Rezoning Transportation Analysis

Petition Number: 2020-122

General Location Identifier: Tax ID (02718124)

| Date | Description |
|----------|--------------------|
| 12-28-20 | Fourth Review (EL) |

RZ-1.0

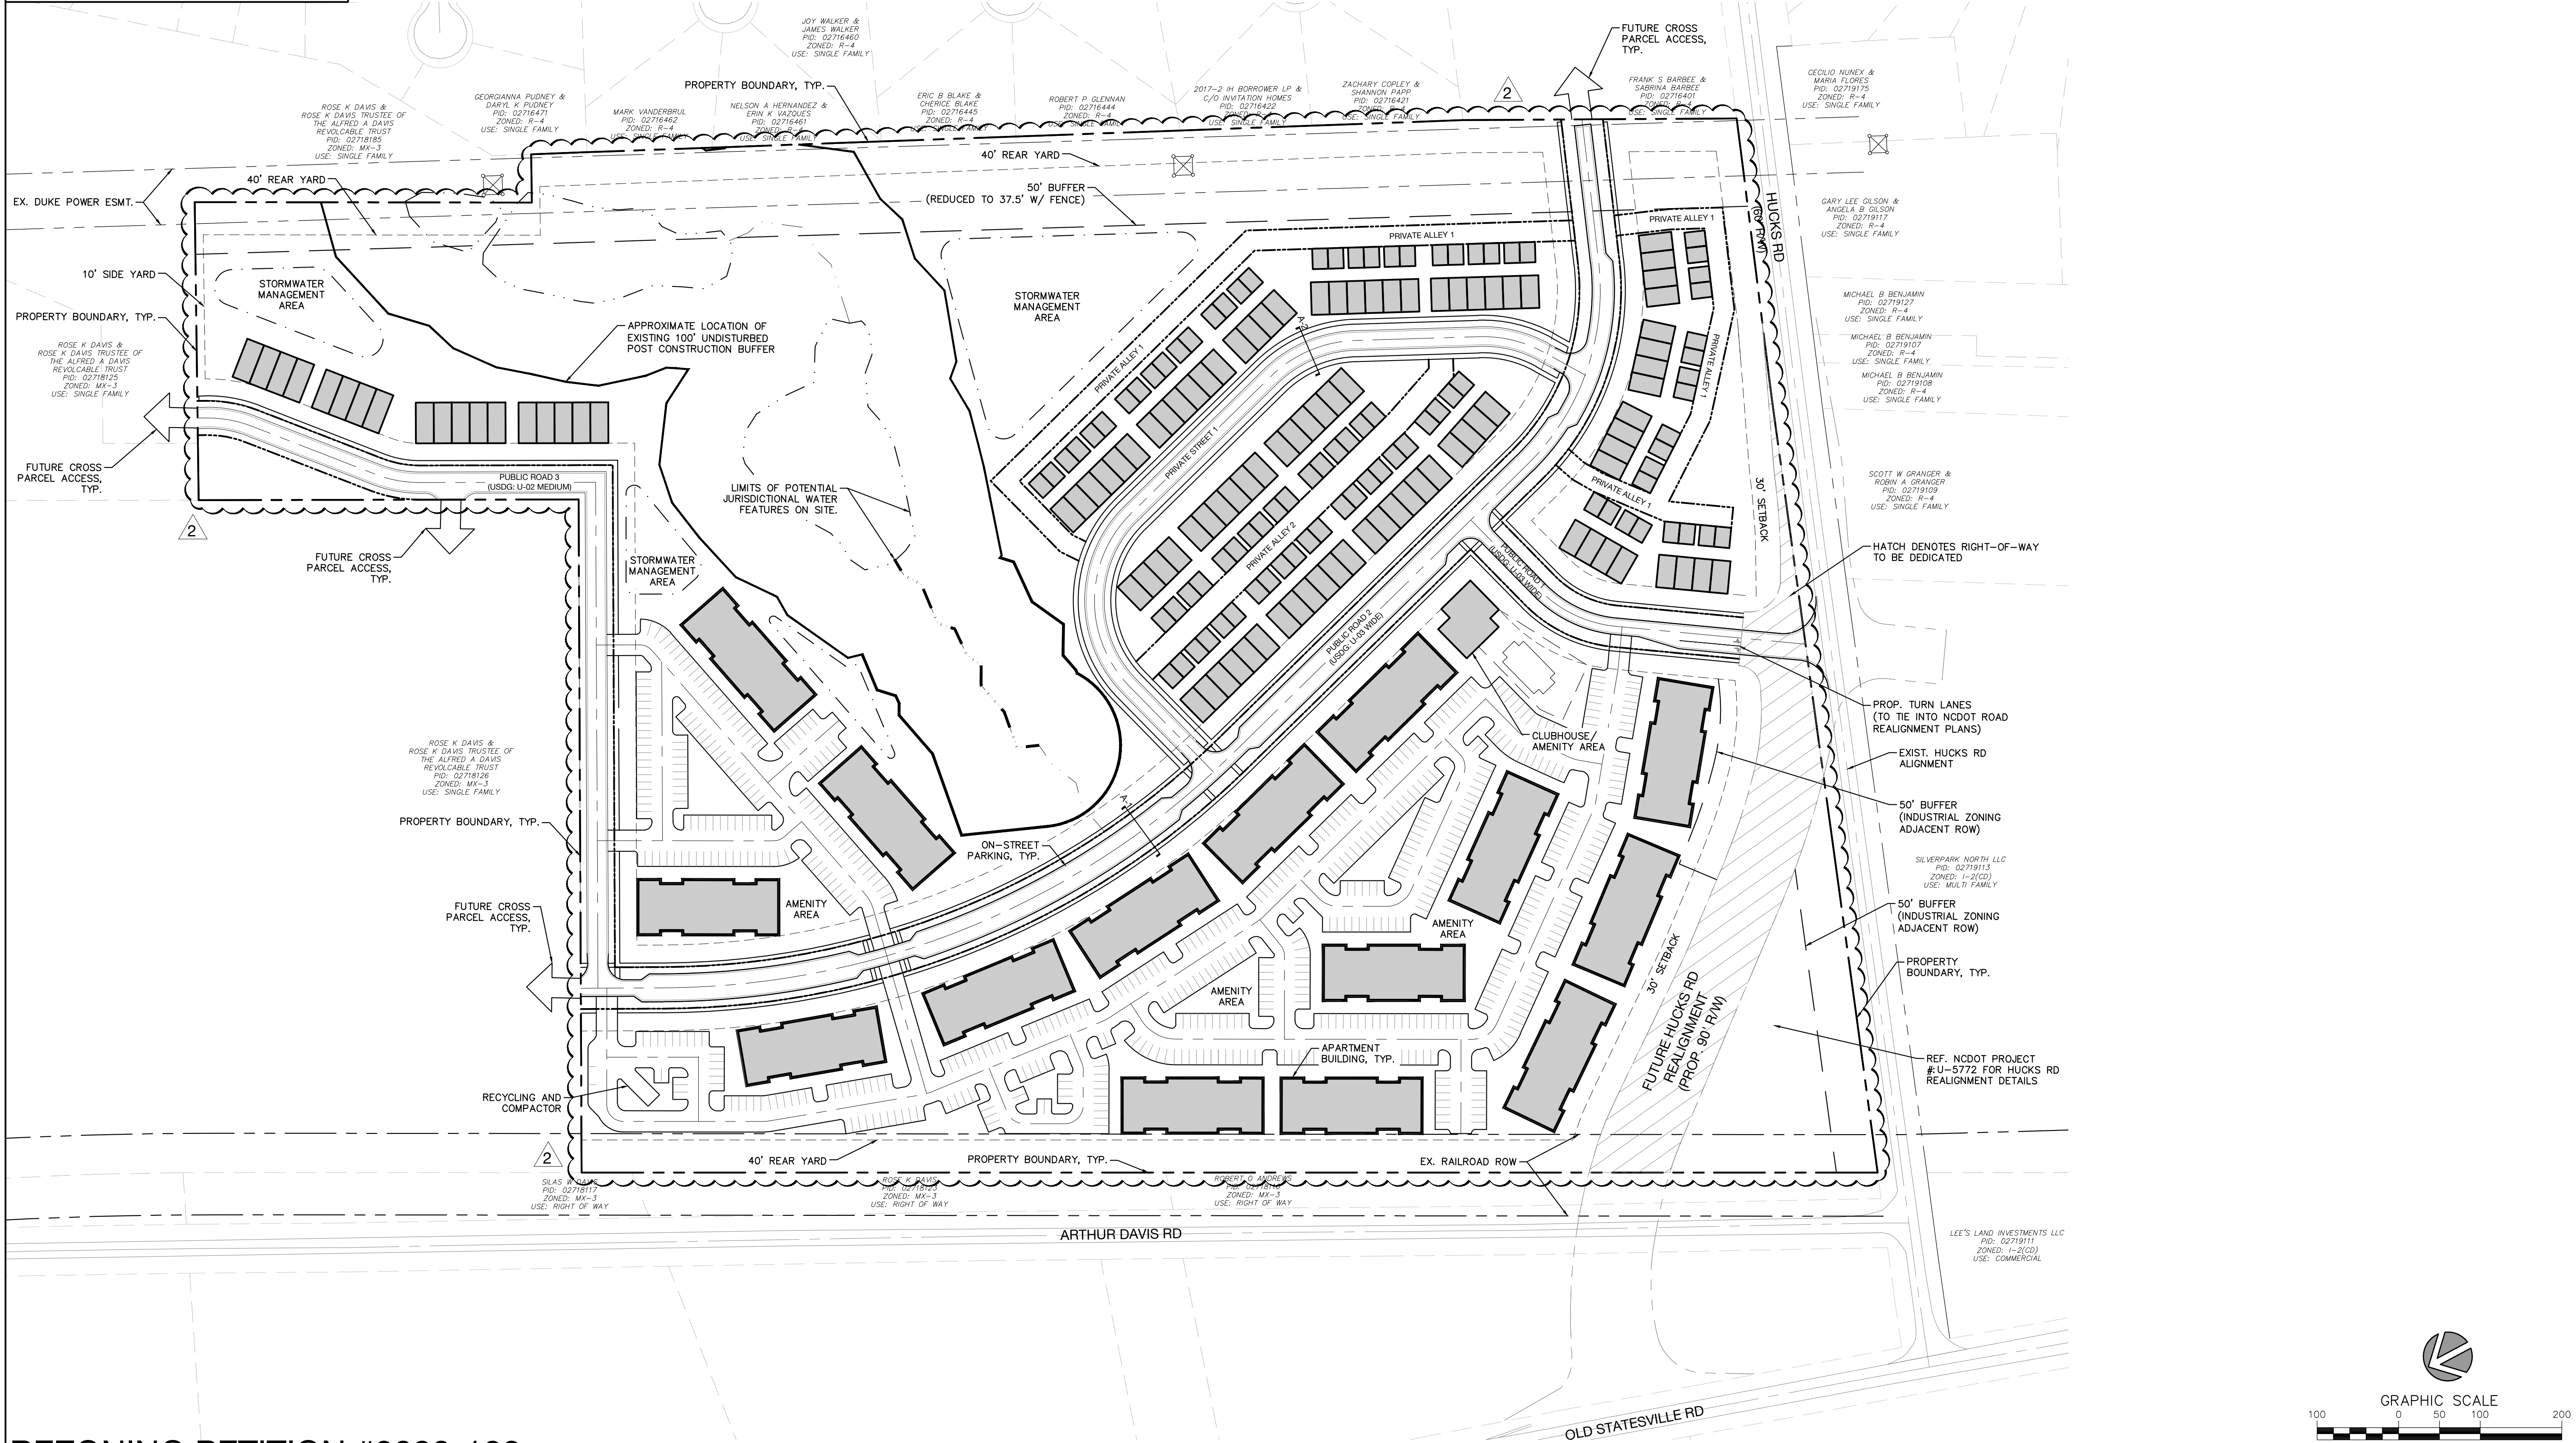
- Outstanding (site plan dated 10.12.20):** Revise the site plan and conditional note(s) to commit to construct the Hucks Road Realignment cross section as in the approved TIS scope. In lieu of a raised, curbed median island, install asphalt and a striped median instead. This will ensure that CFD can safely maneuver through the area. Construct the multi-use path as per CLDSM standards. **Dedicate public right-of-way and temporary construction easement limits, as included within the NCDOT STIP U-5772 25% design plans, sheets 12 and 20.**

6. Revise the site plan to add a note specifying dedication and fee simple conveyance of all rights-of-way to the City before the site's first building certificate of occupancy is issued. CDOT requests right of way set at 2' behind back of sidewalk where feasible.

9. **Outstanding (site plan dated 10.12.20):** Submit a [Right of way Abandonment Petition form](#) to CDOT for review of the potential abandonment of existing Hucks Road, with the commitment to construct the portion of Hucks Road Realignment, as shown on the site plan dated **7-10-2020**, dependent upon outcome of coordination with CDOT. The decision of this rezoning petition does not correlate with the decision of the possible abandonment, as this decision is issued within the separate Right-of-Way Abandonment process that is controlled by North Carolina General Statutes.
